DOC19/261143  
SSD 9368

**Alex Avenue Public School State Significant Development, Farmland Drive, Schofields (SSD 9368)**

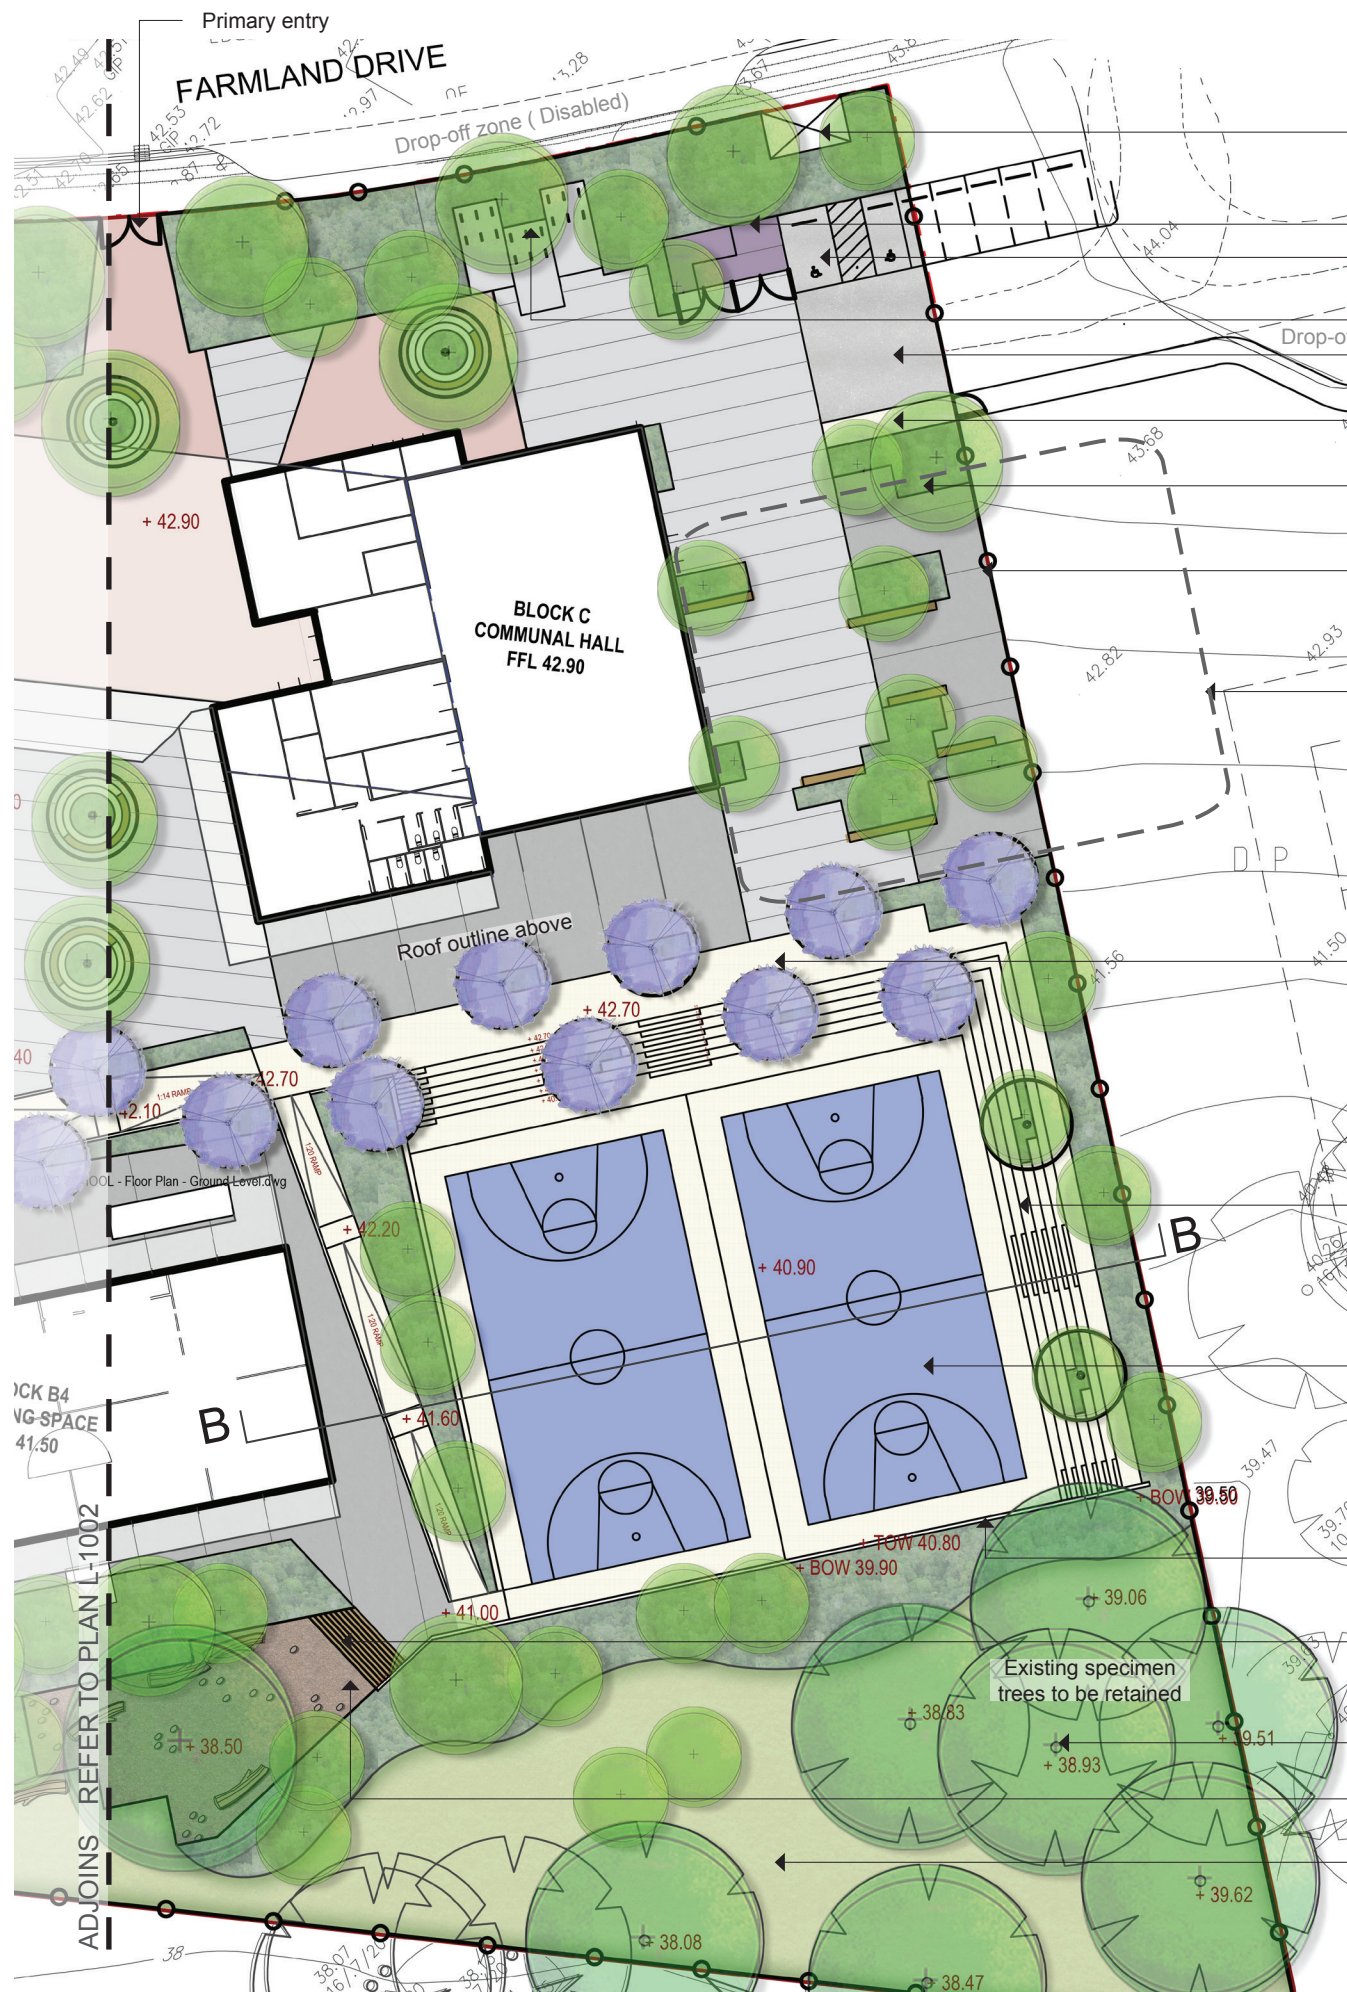
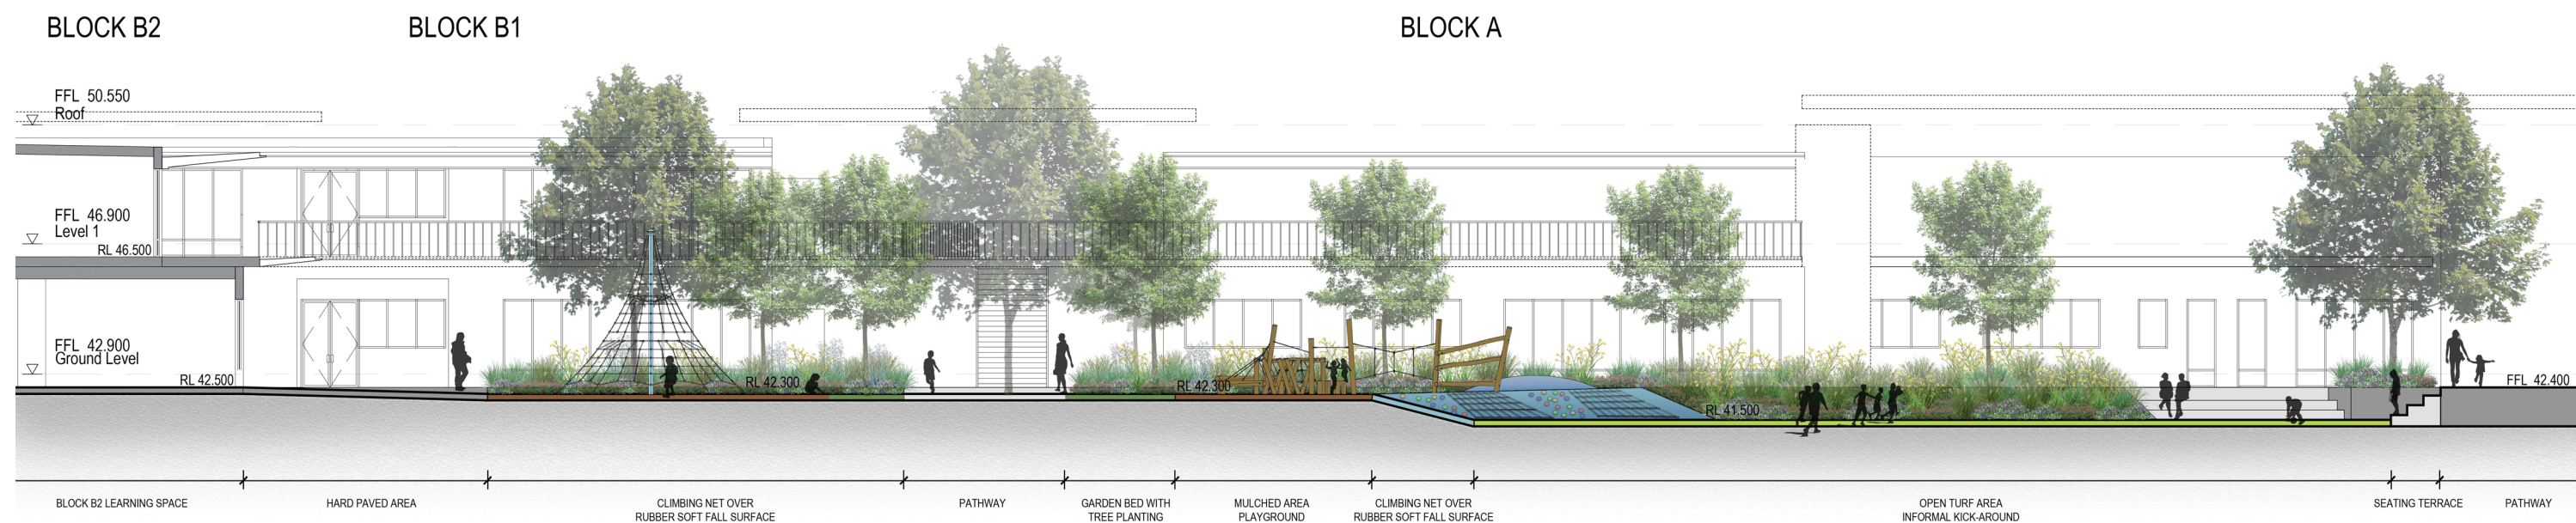
The Office of Environment and Heritage (OEH) has reviewed the Environmental Impact Statement (EIS) supporting the DA and notes from the Urban Design Report that '*native planting to contribute to the surrounding natural ecology*' is one of the key environmental strategies included in the design to '*foster a culture of environmental sustainability*'. OEH supports this strategy and is encouraged by the Landscape Plans which indicate remnant native eucalypt trees (Narrow-leaved Ironbark [*Eucalyptus crebra*]) in the southern part of the site will be '*retained and protected*'. As detailed in the Flora and Fauna Assessment, these trees are remnants of the critically endangered Cumberland Plain Woodland (CPW) vegetation community which once covered the site. To further improve the biodiversity outcomes of the development, OEH recommends the exotic Kikuyu turf proposed as groundcover in this area be replaced by endemic CPW species.
